**Addendum No. 1**

RE: Contract # C204918  
WBS # 2024CPT.05.10.10321.1, 2024CPT.05.10.10921.1  
STATE FUNDED  
**Durham and Wake Counties**  
3 SECTIONS OF NC-55

**February 20, 2024 Letting**

The following revisions have been made to the sketch maps.

Wake 55	
PROJECT REFERENCE NO.	SHEET NO.
2024CPT.05.10.10321.1, ETC	<b>1</b>

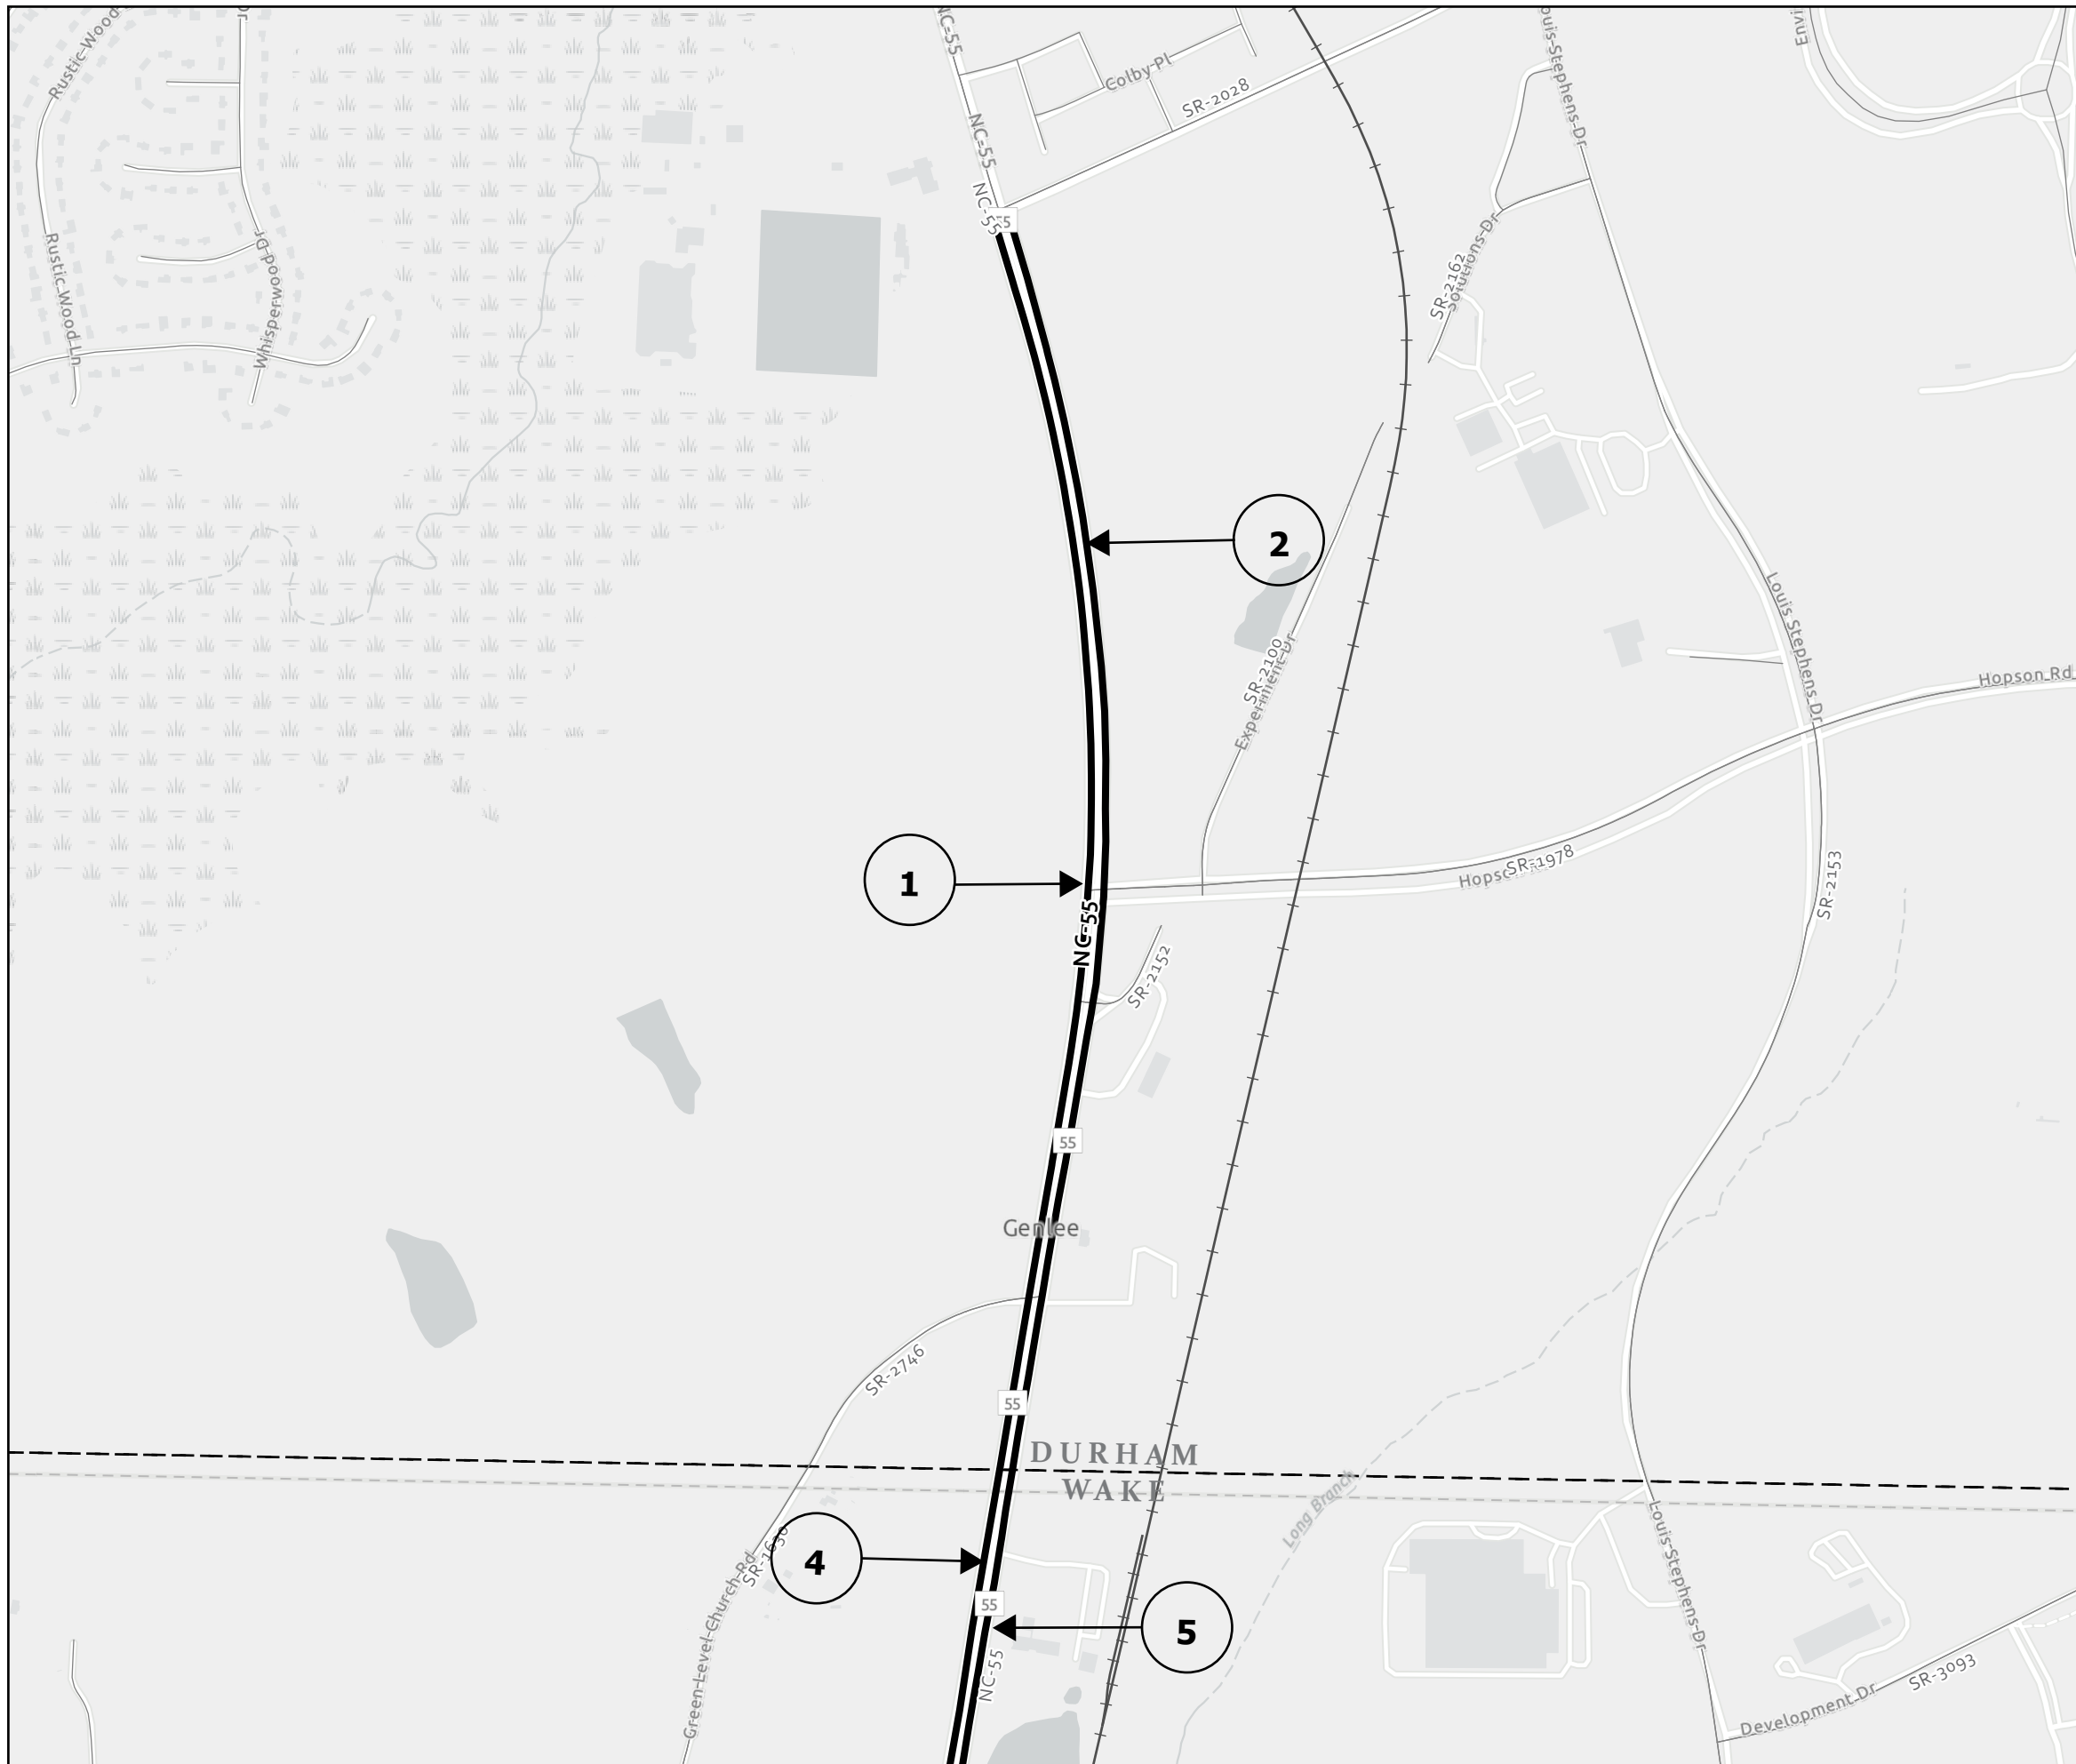
| Sheet No. | Revision   |
|-----------|--|
| 1-8       | Vicinity Map descriptions updated to match Summary of Quantities Map descriptions. |
